Date: 03/27/2024

Re: **I-Joist Layout Issue**
Location: Lot 4 Honeycutt Hills (69 Shelby Meadown Ln. (Angier, NC))
JDS Project No.: RDU2403203
Date of Inspection: 03/26/2024

**FIRST FLOOR FRAMING PLAN - CRAWL SPACE**  
SCALE: 1/8" = 1'-0"

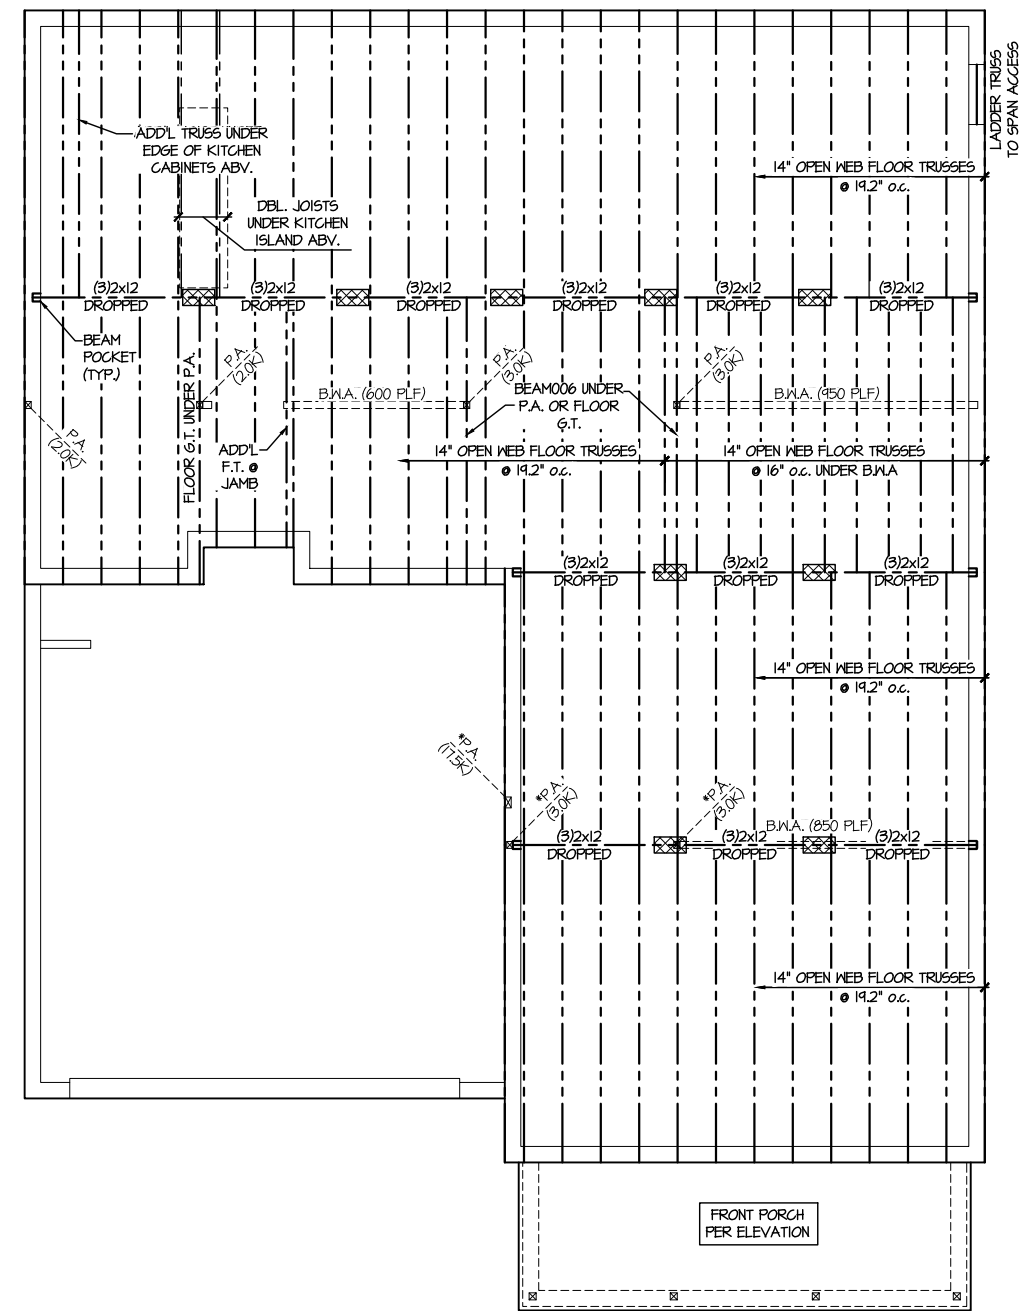
A client requested an evaluation of the I joist layout for the first floor. The layout was not per the structural plans provided, but follow the truss layout provided by the manufacturer.

Based on our observations and review, the truss layout is per the manufacturer’s specifications, no repairs are required.
